**RE: Dutch Bros 2501 Juan Tabo Blvd. NE
Traffic Circulation Layout**

Isaacson & Arfman, acting as agents for Accelerated Development, the Developer of the above-referenced project, is applying for Traffic Control Layout for Building Permit. A conceptual TCL was previously submitted with Engineer Stamp Date 10-24-2022 and comments were provided. The following is an explanation of how those comments have been addressed.

SHEET NUMBER  
**FIRE 1**

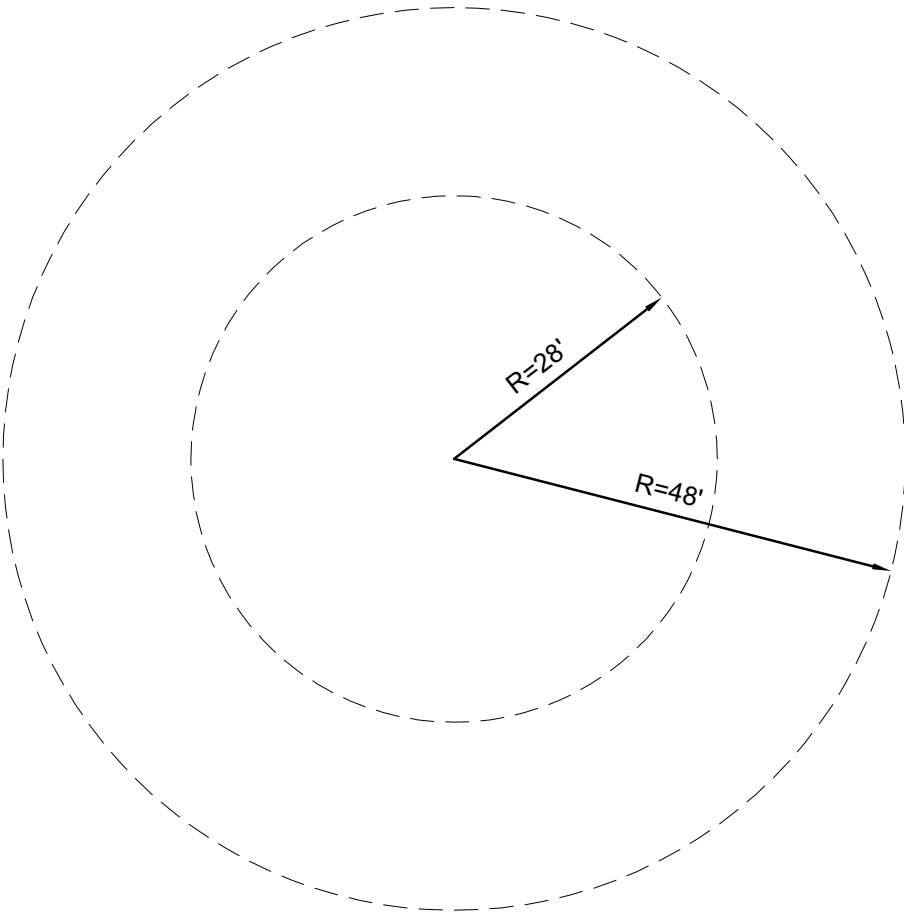
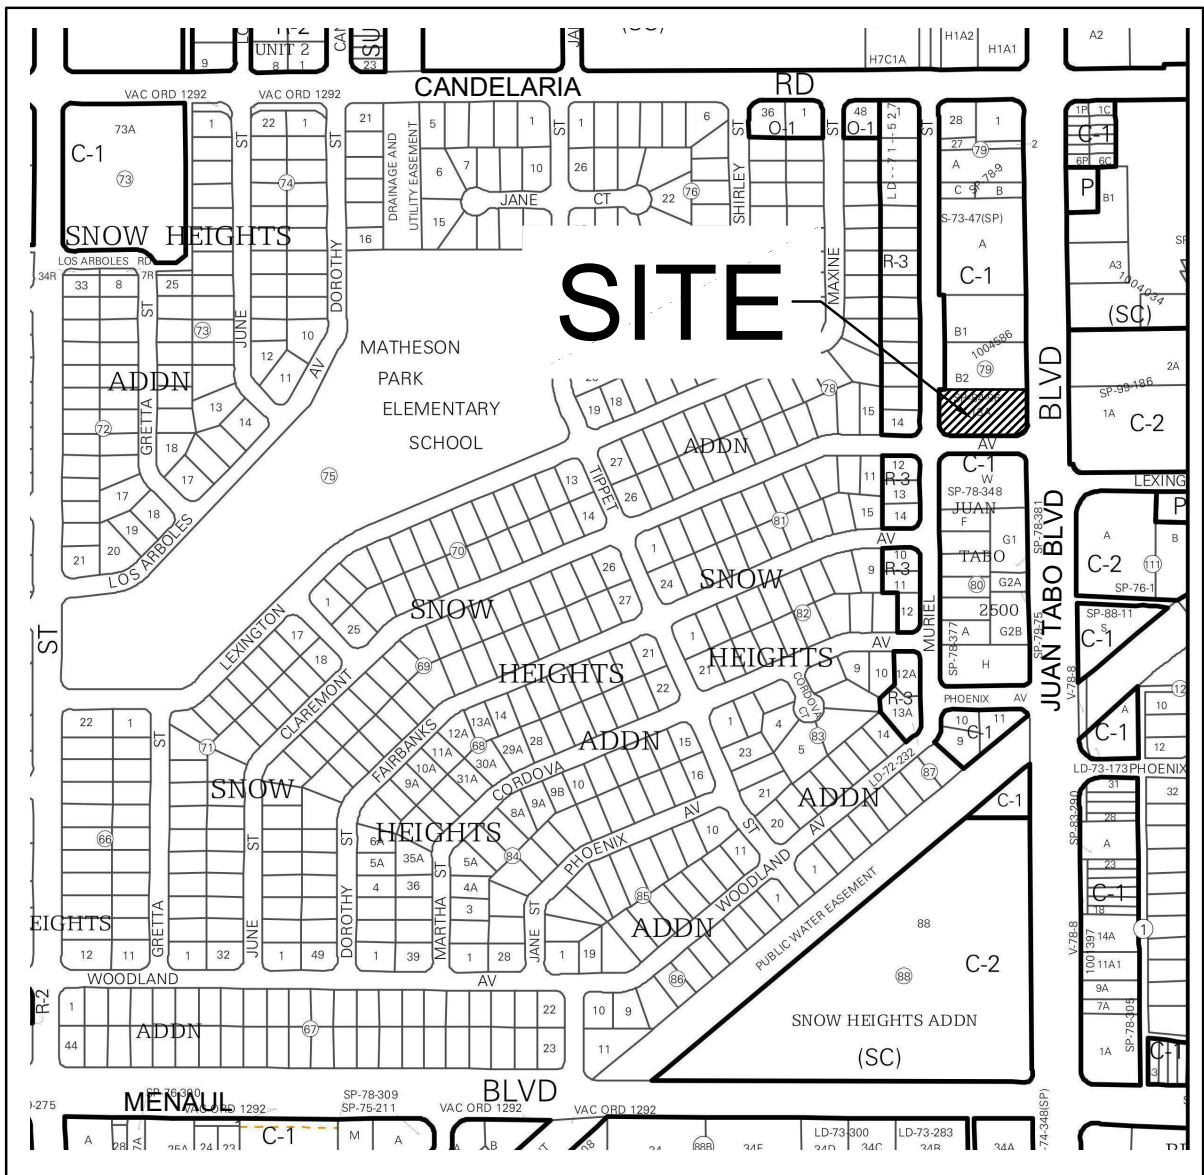
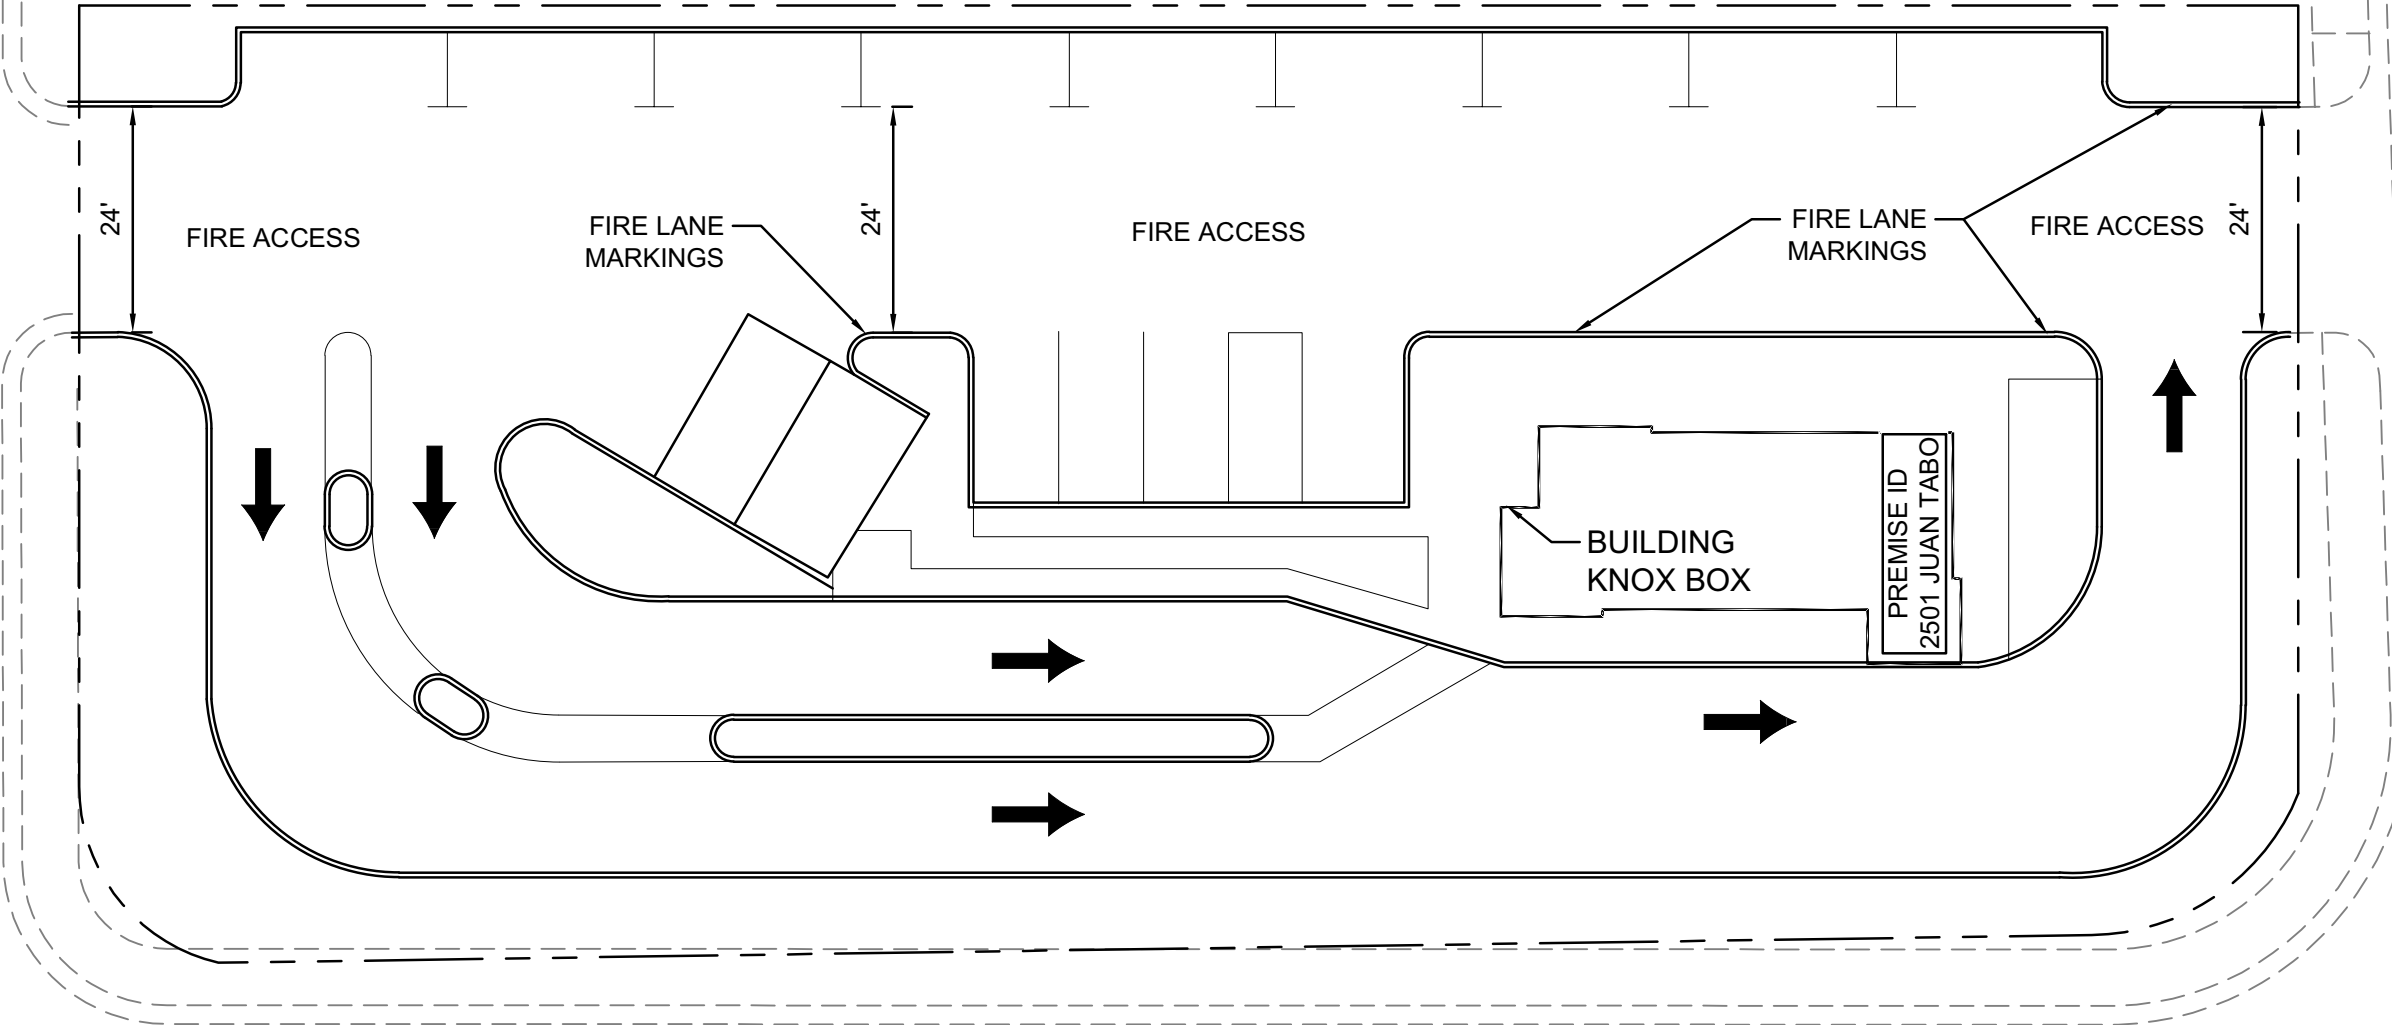
18. Approved Fire 1 included in attachments.
19. Site signage details have been included. These signs have been used on other Dutch Bros projects in Albuquerque.
20. A sight distance exhibit is included.
21. Clear sight triangles have been added to the plan.
22. The plan has been updated to include COA STD DWG numbers.
23. The plan has been revised to address this item.
24. <this letter>
25. Completed Traffic Scoping Form in attachments.

CP-401

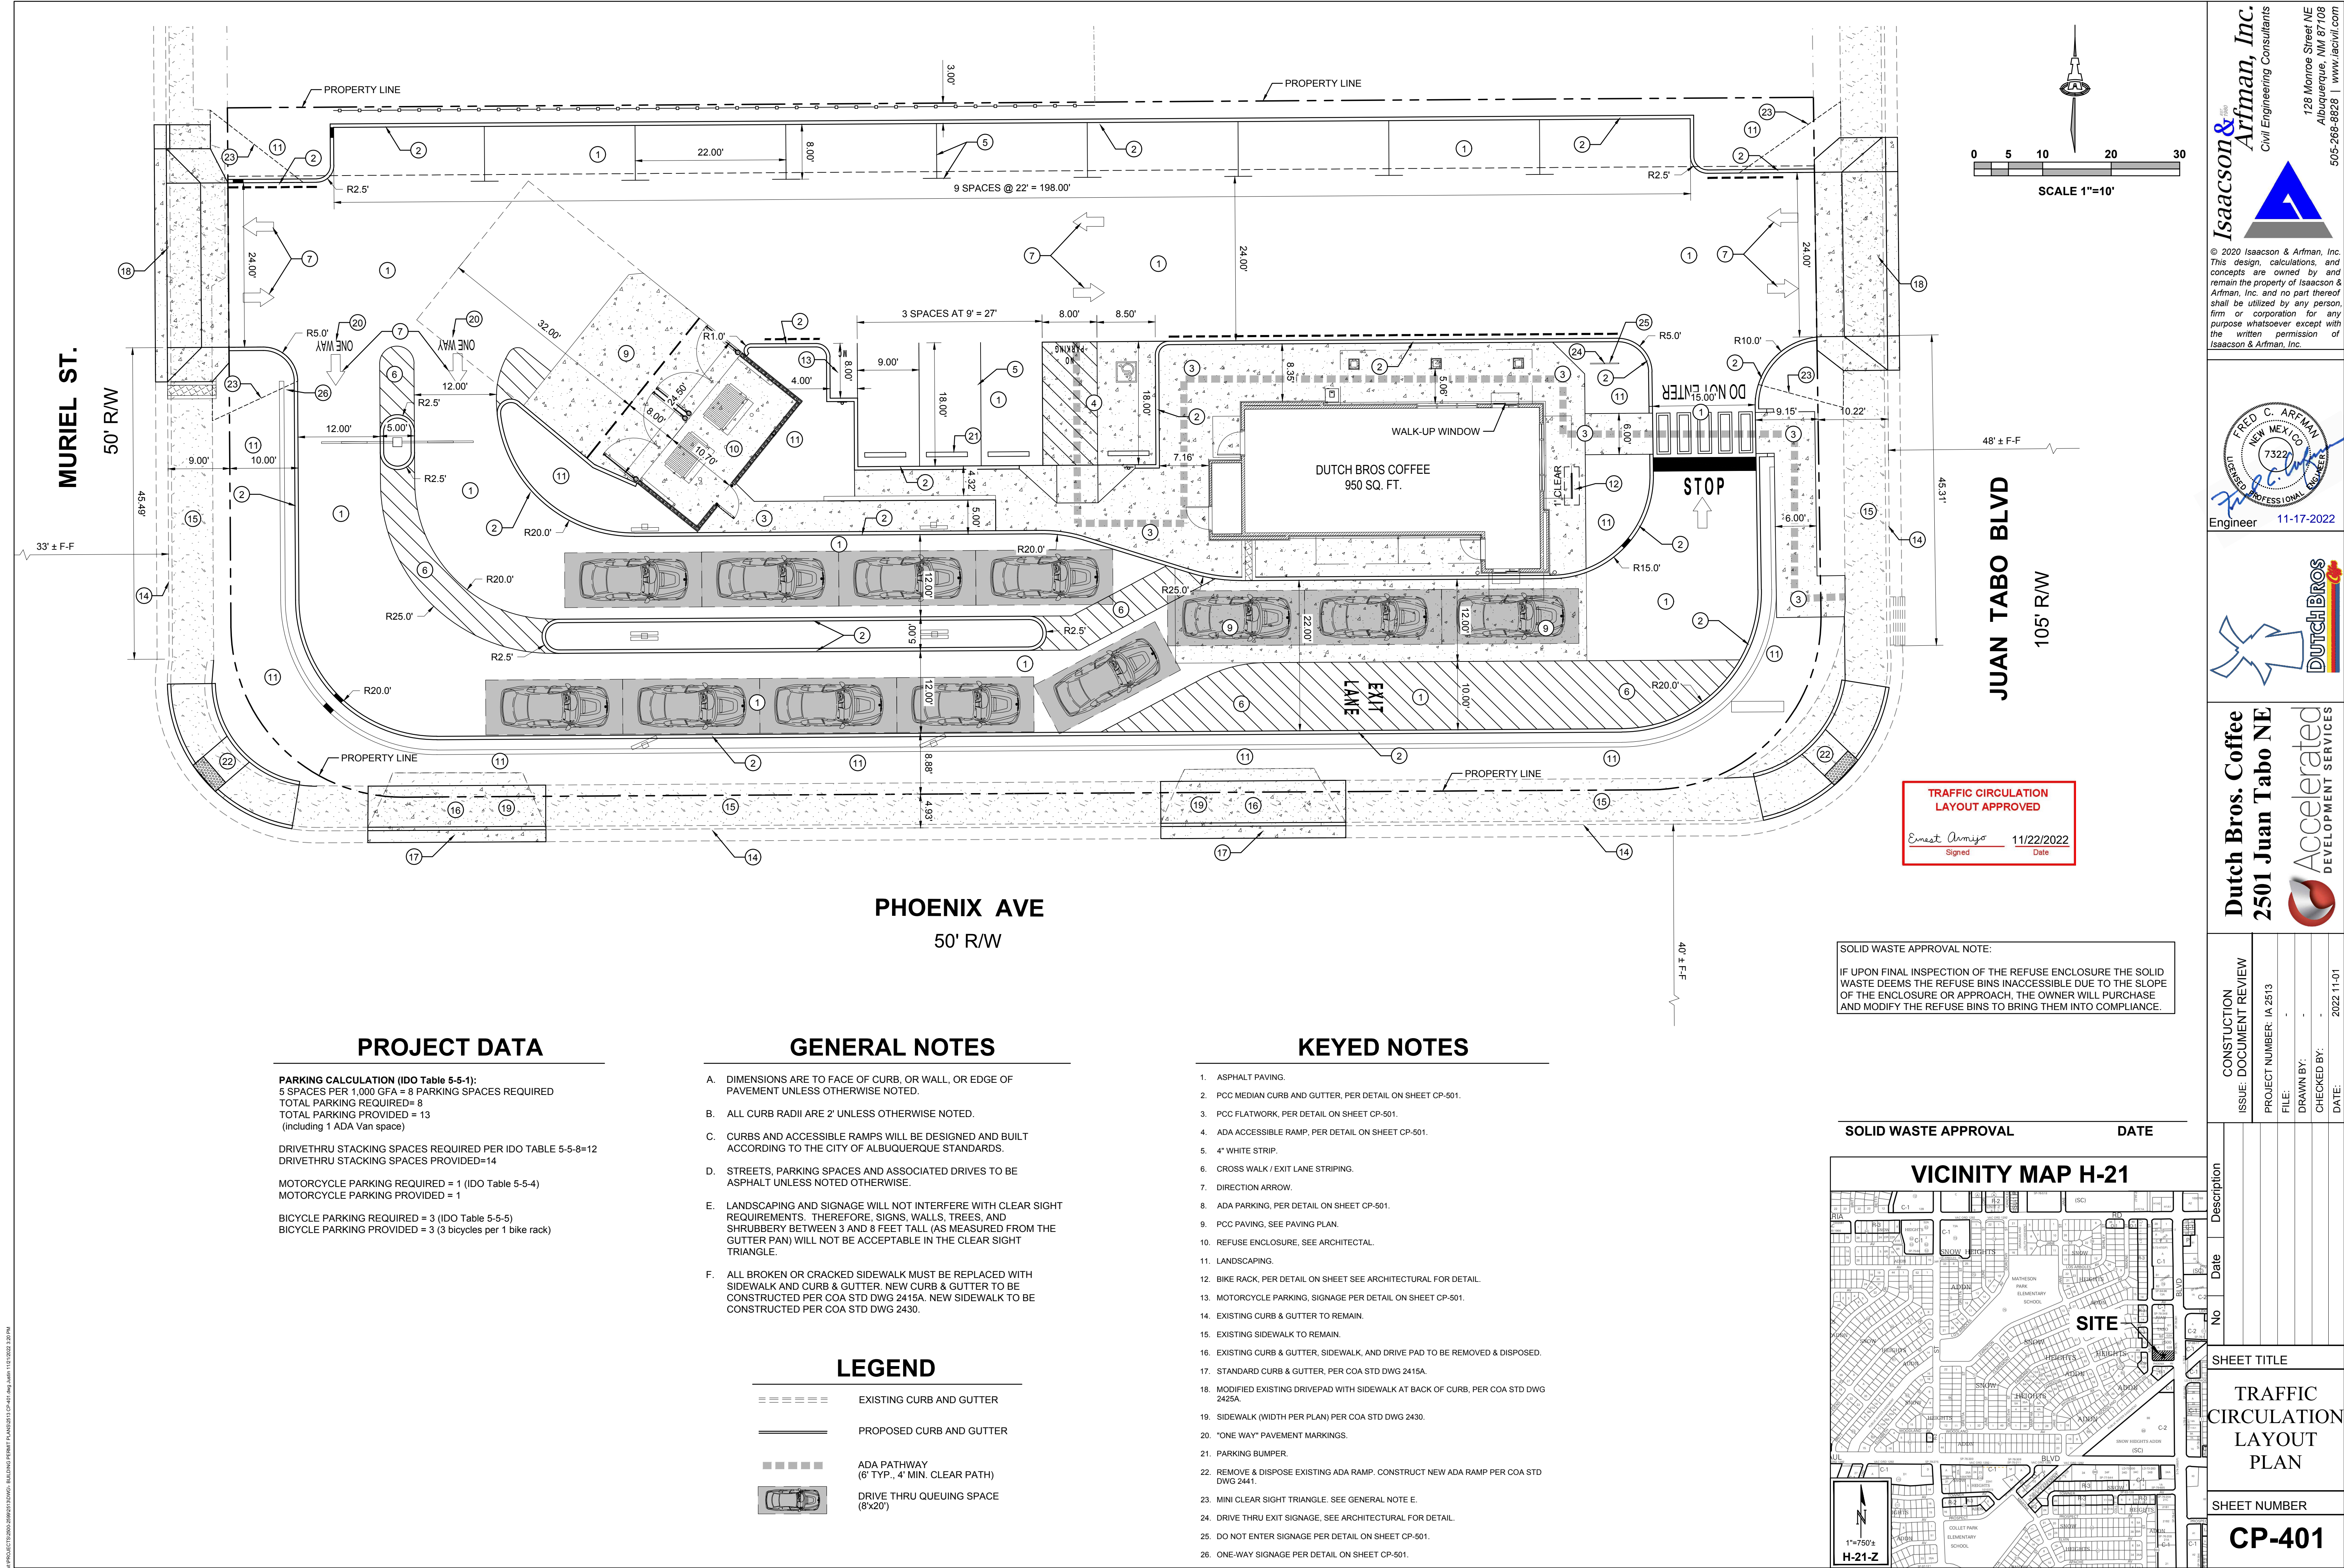
4. Radii dimensions added to Juan Tabo entrance.
5. See response 3 above.
6. The ADA space has been modified to be 8.5' wide.
7. The entry along Muriel is existing and we are proposing to modify it to comply with COA STD DWG 2425A per direction from Ernest Armijo. Keyed notes have been added to the plan.

8. The plan has been updated to include reconstructing the ADA ramp as requested.
9. See response 8.
10. The plan has been updated to show the car queuing.

11. Bicycle parking and associated details have been added to the plan.
12. See response 11.
13. See response 11.
14. See response 11.
15. A 6' ADA path has been added to the plan from R/W and ADA parking to doors.
